WELWYN HATFIELD BOROUGH COUNCIL – DEVELOPMENT MANAGEMENT
DELEGATED REPORT

APPLICATION No: N6/2015/1119/OR

SITE ADDRESS: Everest House, Sopers Road, Cuffley, Potters Bar, EN6 4SG

DESCRIPTION OF DEVELOPMENT: Prior approval for the change of use from B1(a) Office to Class C3 (Dwellinghouses)

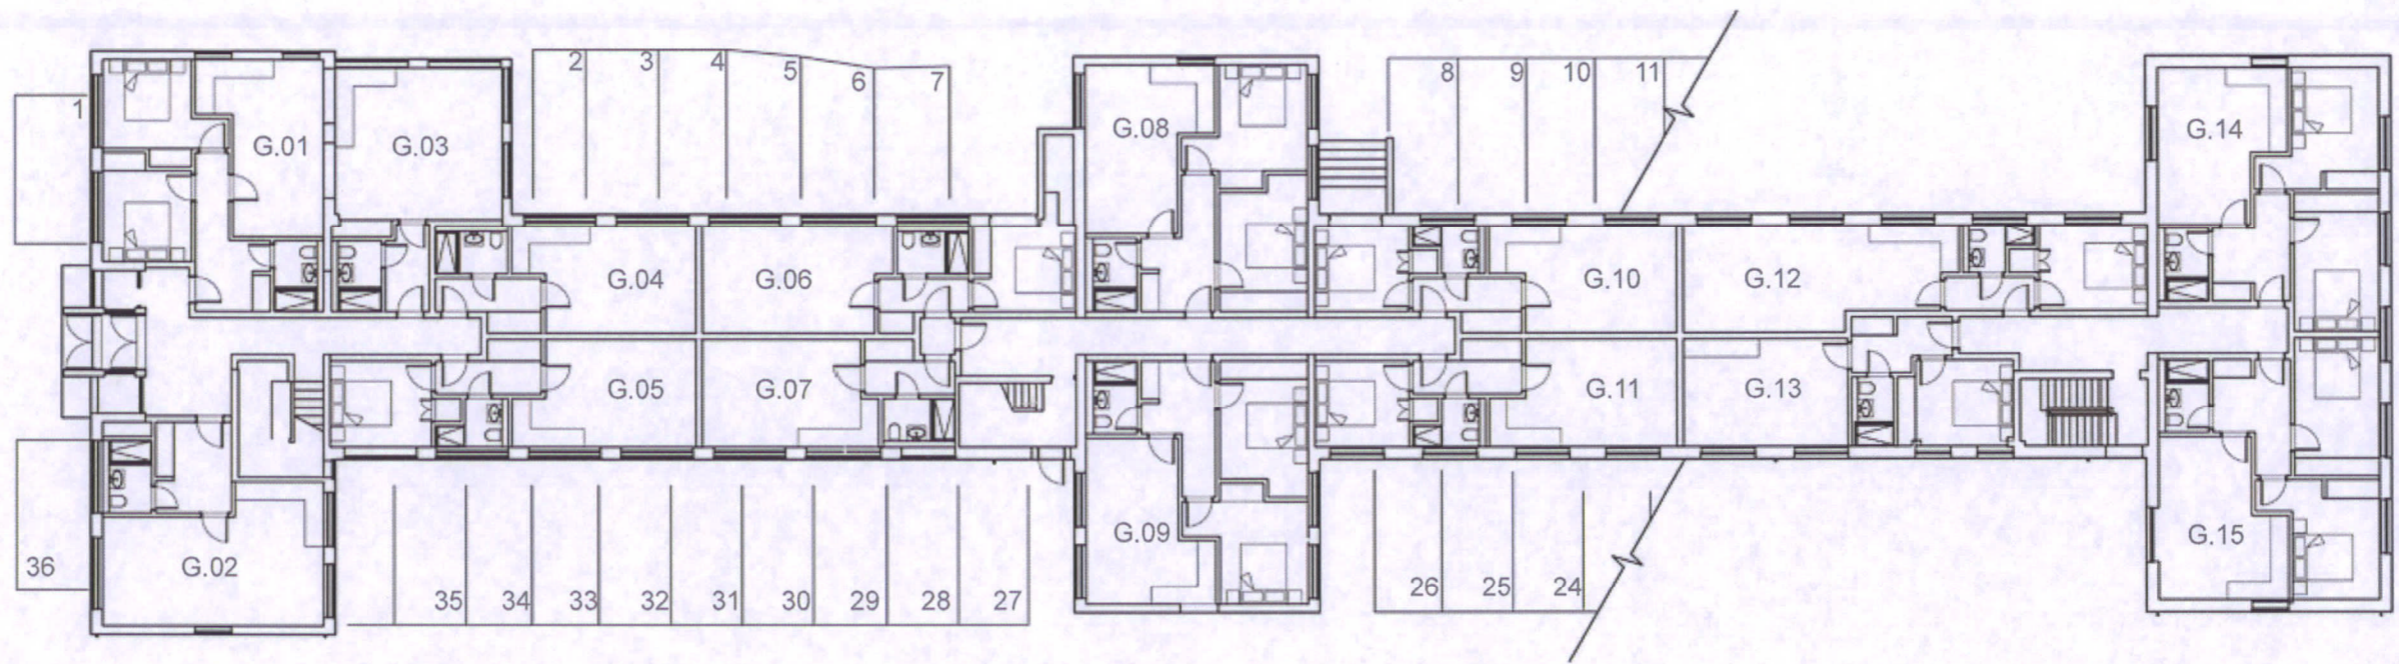
Welcome provision of cycle parking. The bin store appears to have no connection to the outside.

Forty three car parking spaces are proposed just below one space per flat. The SPG standards include provision for visitor parking and some demand for visitor parking to the application site may be absorbed by the adjacent car park. This provision and the location of the site close to the station and village centre mean that some reduction in parking provision on-site may be acceptable.
